Development Facilitation Team (DFT) – Review Comments

DRB Project No: PR-2022-007492 Date: 04/12/2023 Agenda Item: #3 Zone Atlas Page: C-20

Location: 8950 ALAMEDA BLVD NE between VENTURA ST and BARSTOW ST

Application For: SD-2023-00074-PRELIMINARY/FINAL PLAT (DHO)

**SKETCH
PLAT**

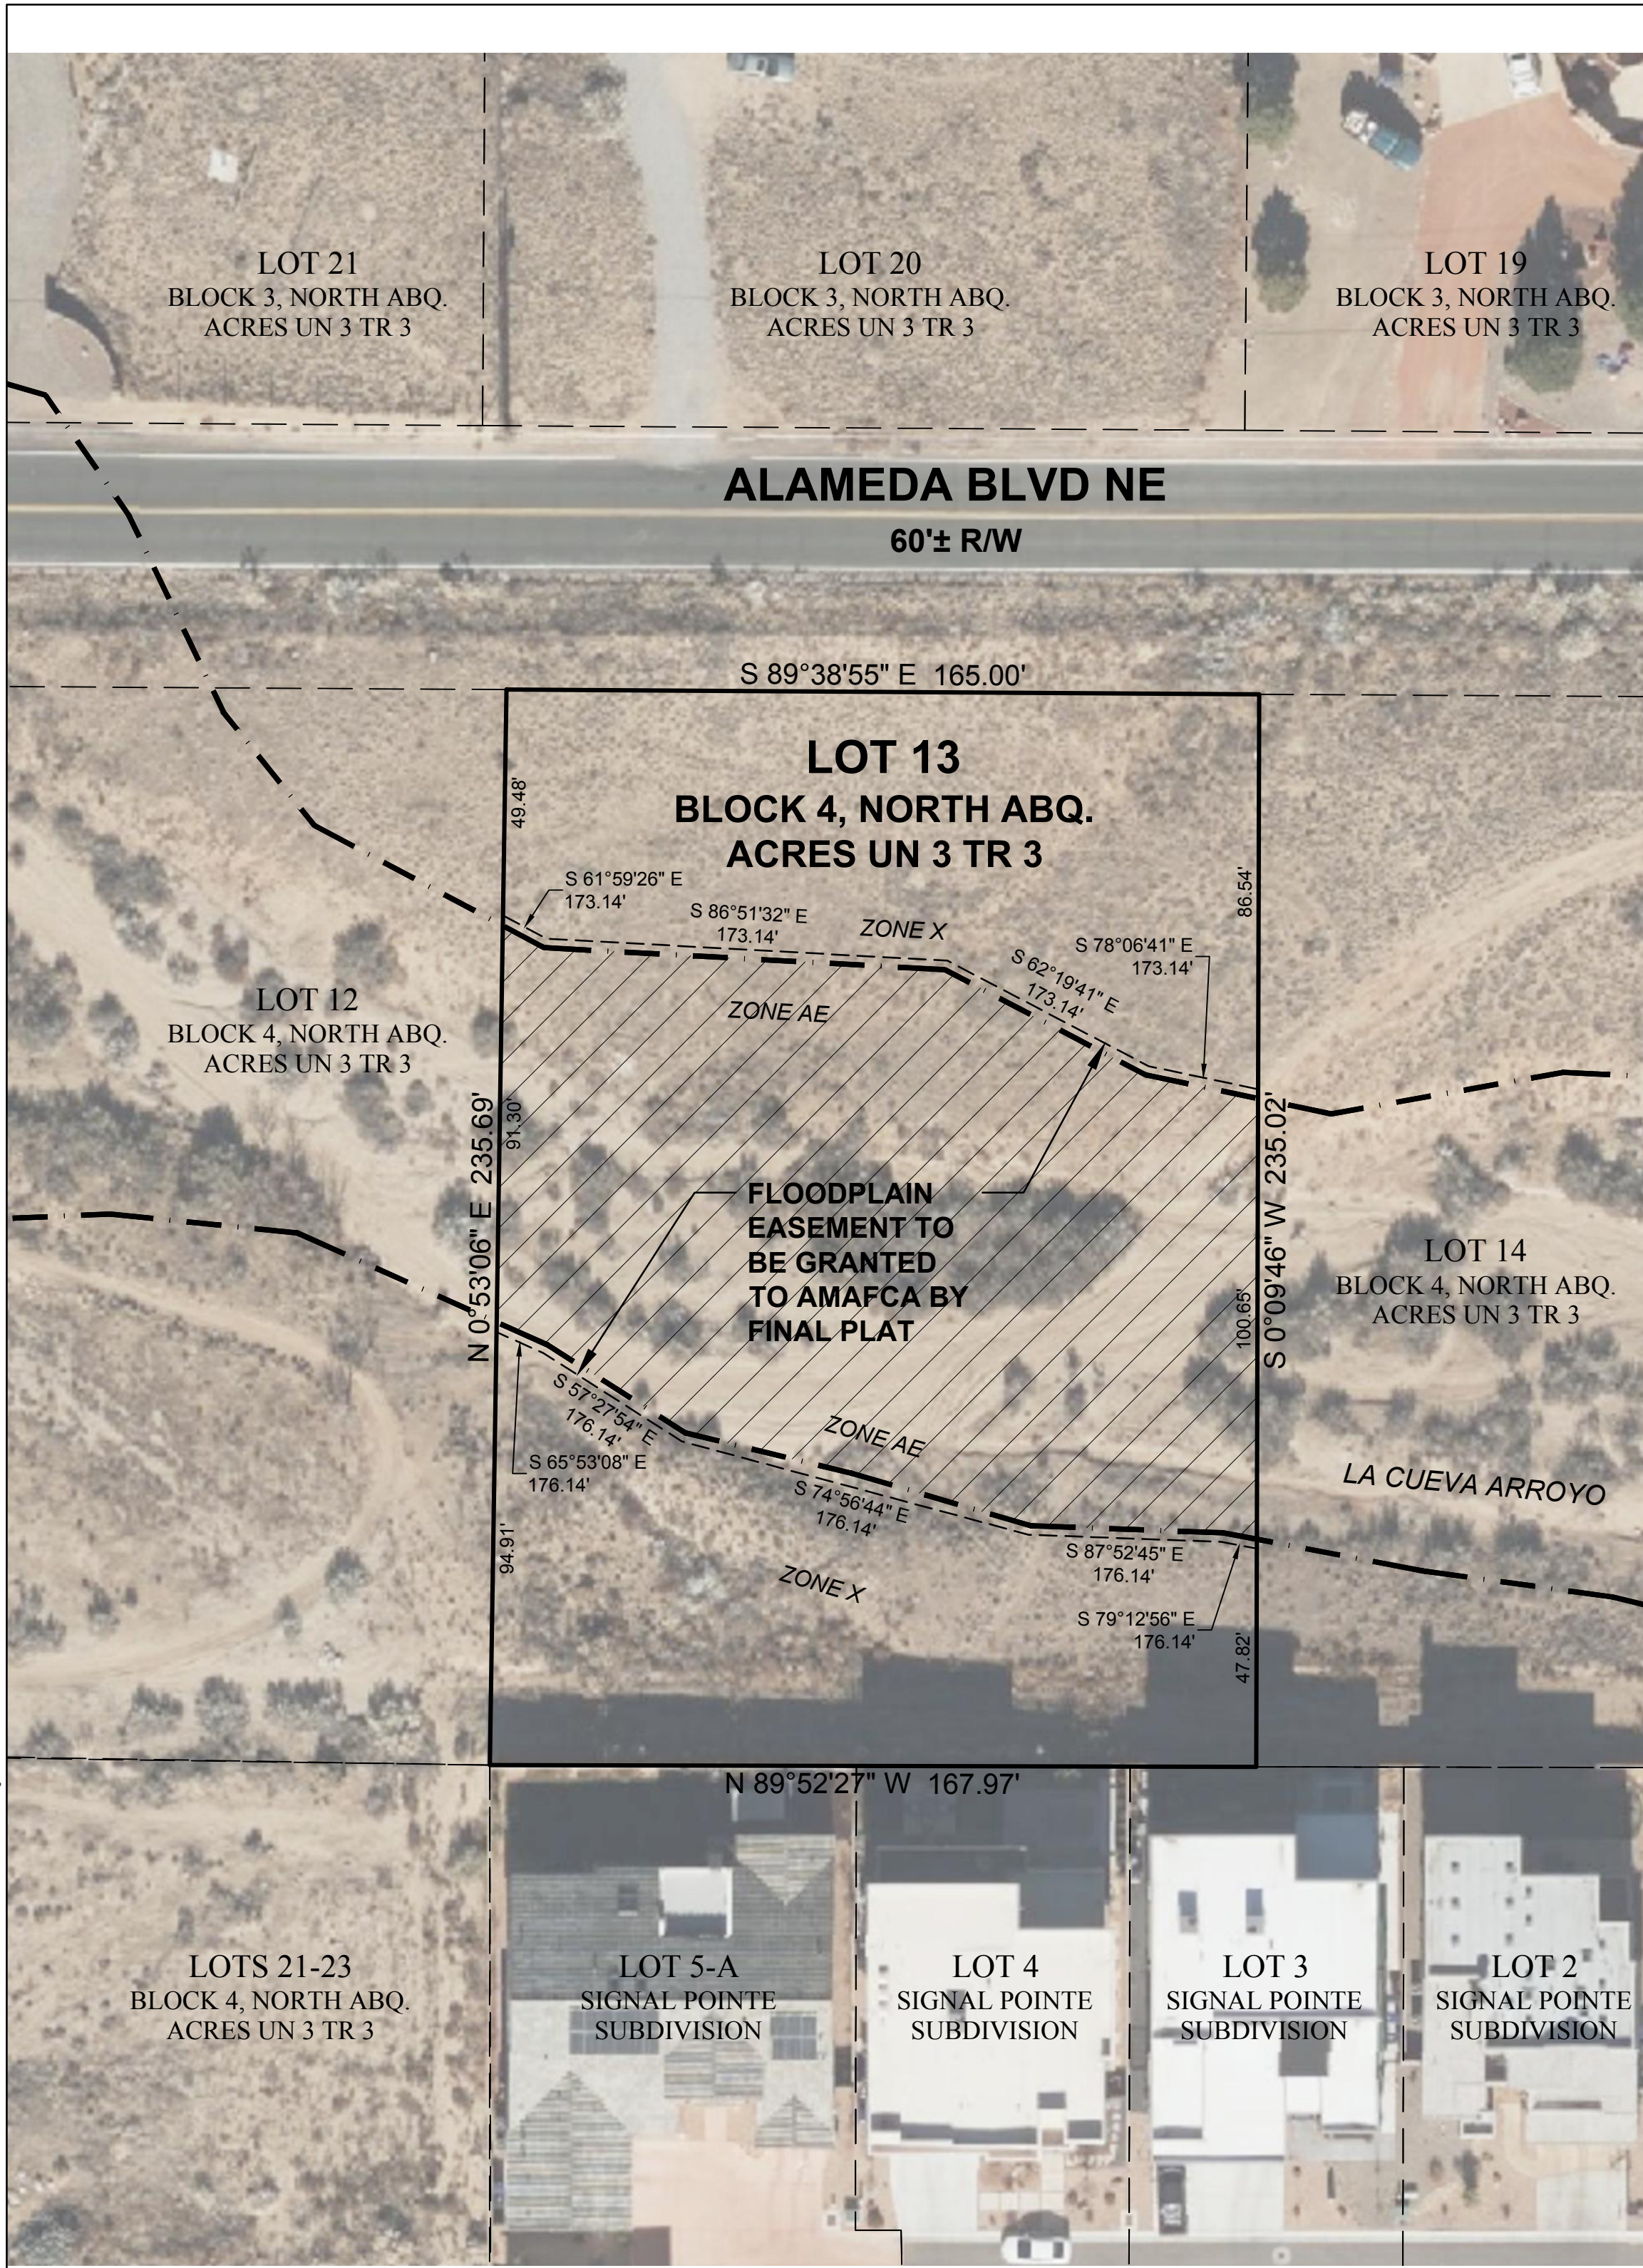
1. This portion of Alameda is a proposed Major Collector and requires 6' sidewalk with a 5-6' landscape buffer. The infrastructure list and figure only show a 5' sidewalk. Please correct this.

- Hydrology has an approved Grading Plan (C20D085). However, it appears that the proposed scour wall is within AMAFCA's Drainage Easement that is to be recorded. Therefore, **Hydrology will need to approve an update Grading & Drainage Plan along with AMAFACA approval.**
- On the Infrastructure List please place the scour wall.

- Per Table 7.2.29 of the DPM, Alameda Boulevard is a Major Collector with a desired sidewalk width of 6 feet and a 5-6 foot landscape buffer. No sidewalk currently exists along the frontage of the subject property along Alameda, and the Infrastructure List features a 5-foot wide sidewalk along Alameda. Planning staff defer to Transportation staff regarding the width of the proposed sidewalk along Alameda as depicted on the Infrastructure List, but notes the DPM guidance for a 6-foot wide sidewalk as well as a 5-6-foot landscape buffer.

It is unclear to me whether the previous comments from 8-24-2022 were addressed. Please clarify whether the indicated ROW for Alameda Blvd includes width for either bike lanes or a multi-use trail as shown in the Long Range Bikeways System Map or whether that requirement has been waived.
